KITTITAS COUNTY
DEPARTMENT OF PUBLIC WORKS

MEMORANDUM

TO: Community Development Services
FROM: Taylor Gustafson, Transportation/Environmental Planner TG
DATE: June 28, 2018
SUBJECT: County Review of LP-18-00002 (Suncadia)

JOB NO.:	998-722-017
DWG. NAME:	PP-02
DESIGNED BY:	JJH
DRAWN BY:	LGB
CHECKED BY:	
DATE:	03/19/2018
PRINT DATE:	
SHEET	
PP-02

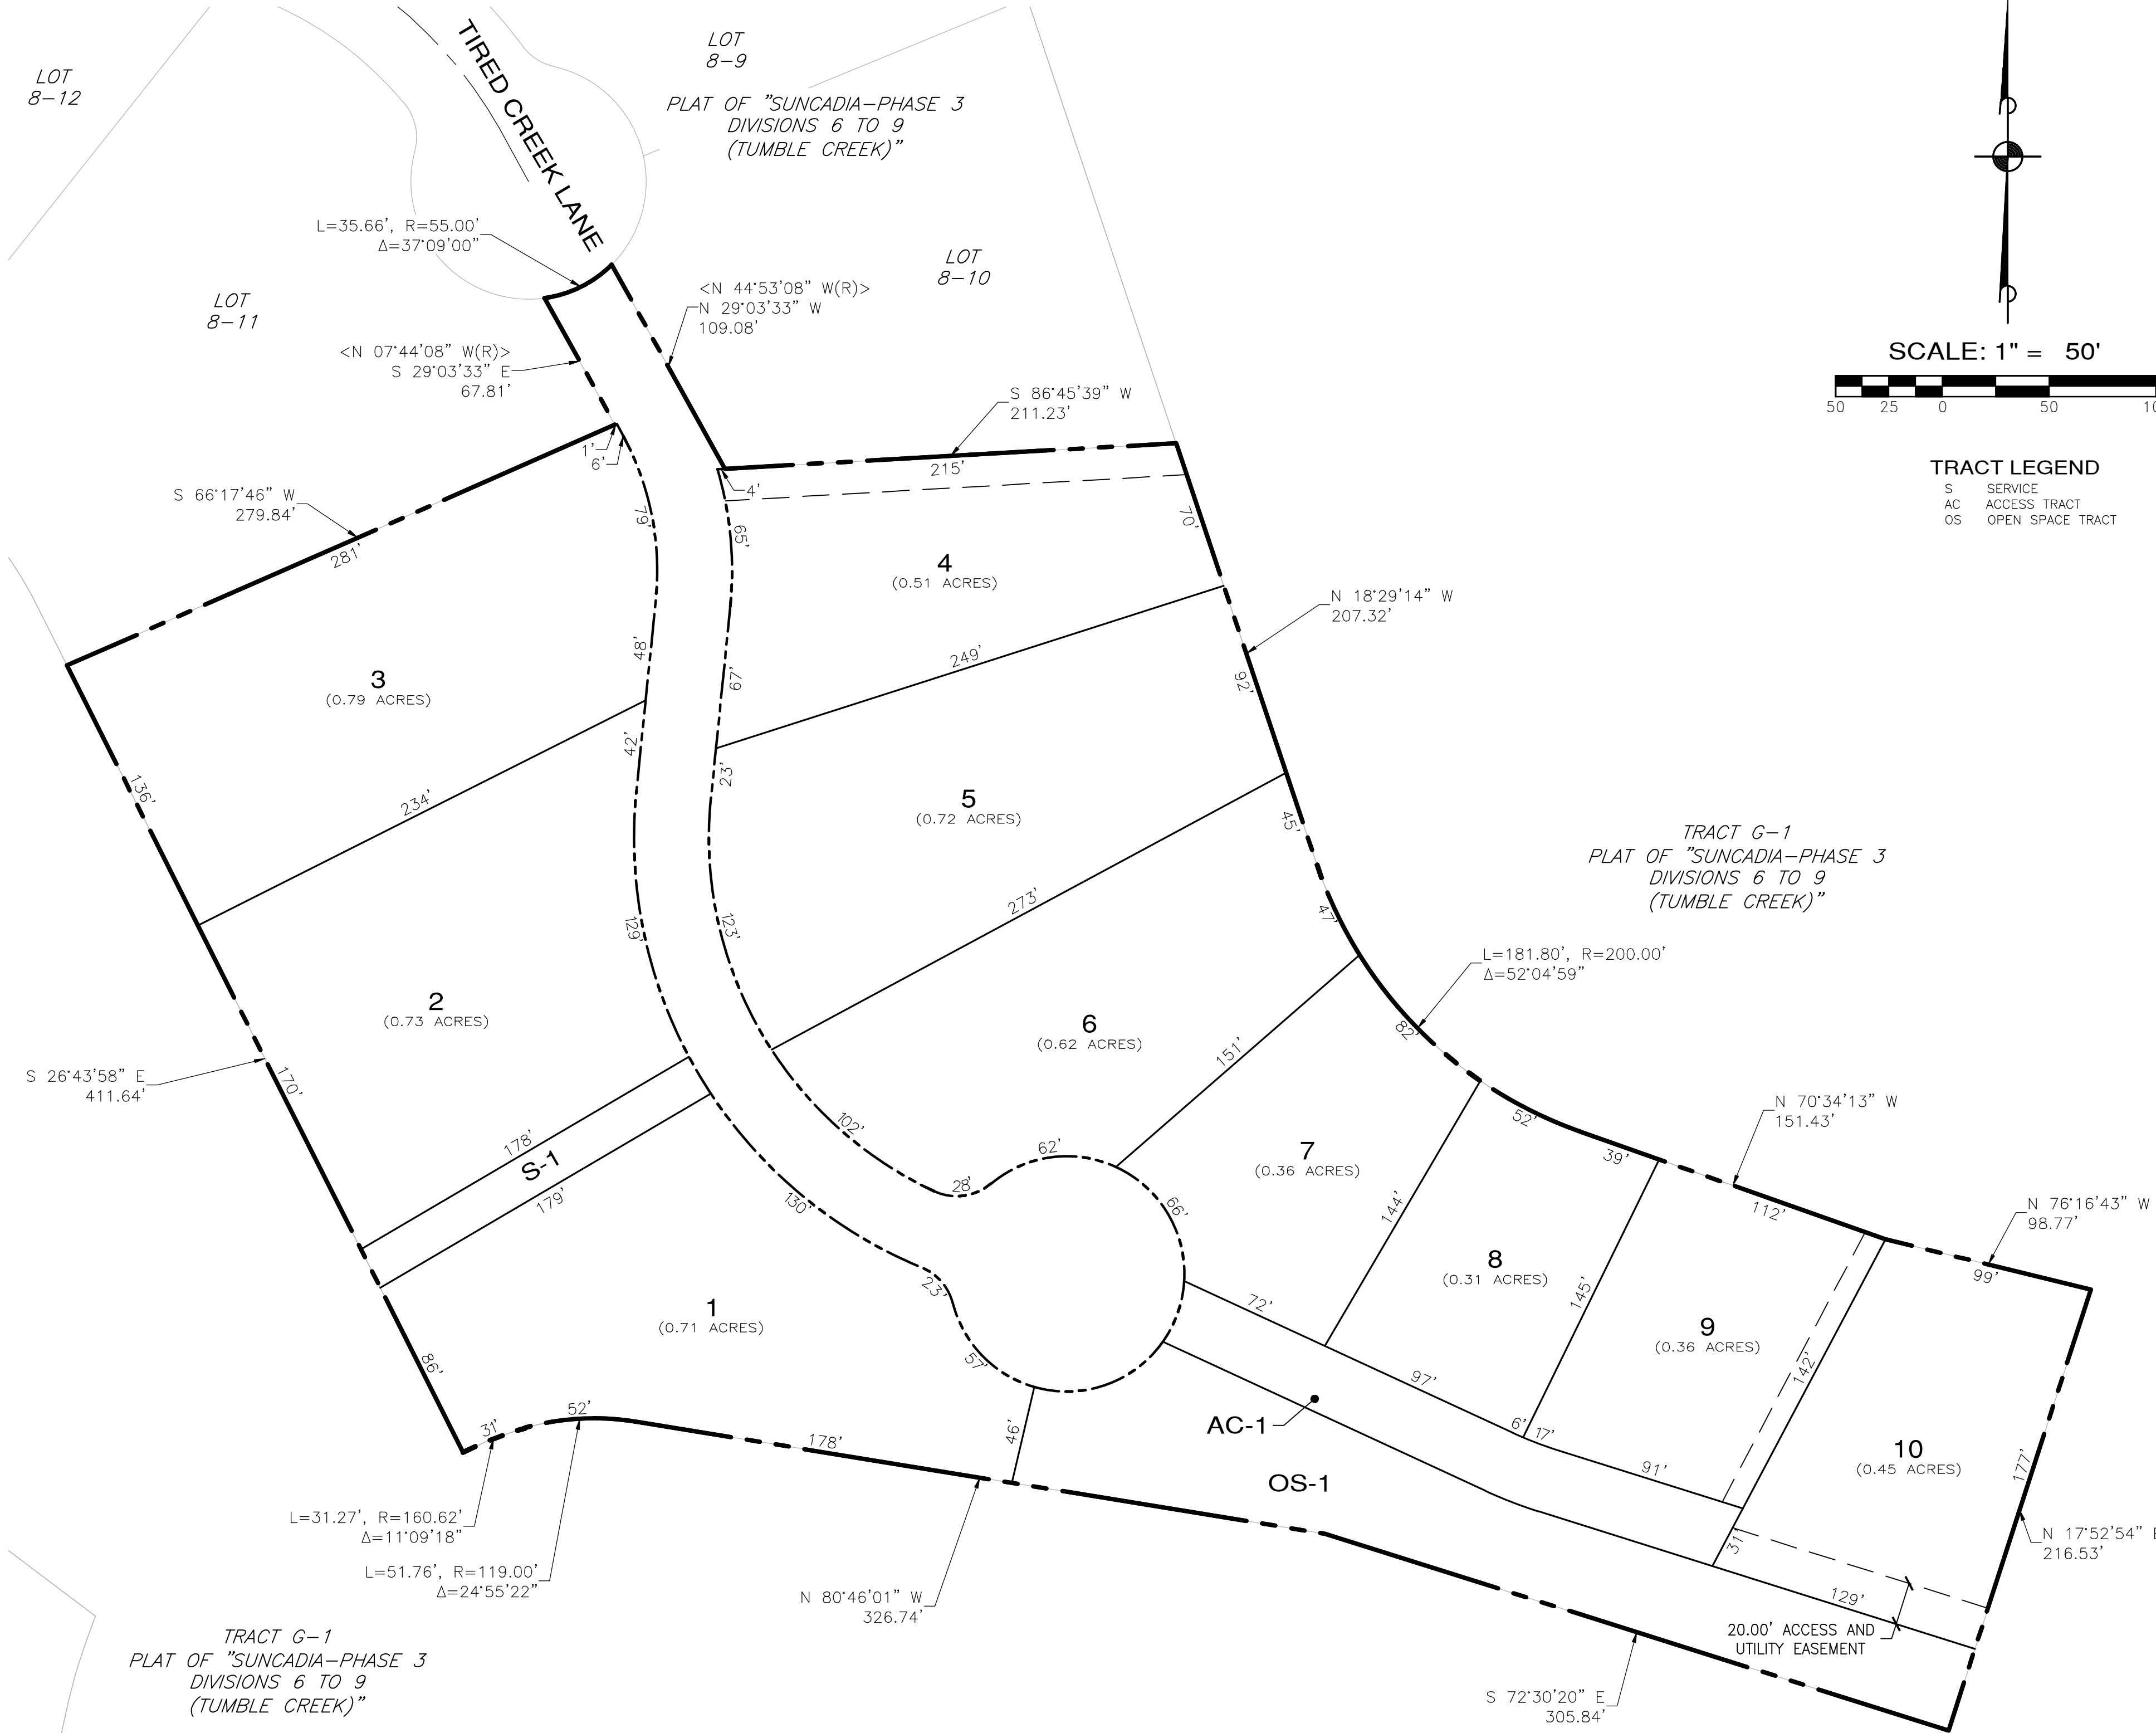
1. The Prelim Plat must include a stamp from a licensed land surveyor on all sheets.
2. All pages must include page number and total number of pages.
3. The intended ownership limits of Lot 10 / AC-1 is unclear. Is AC-1 intended to be 20' wide or 30' wide?
4. Tired Creek lane should include width, ownership and surfacing (EX: TIRED CREEK LANE – 30' wide private R/W-Paved)
5. The Lot area tables should include S-1, AG-1 and OS-1.
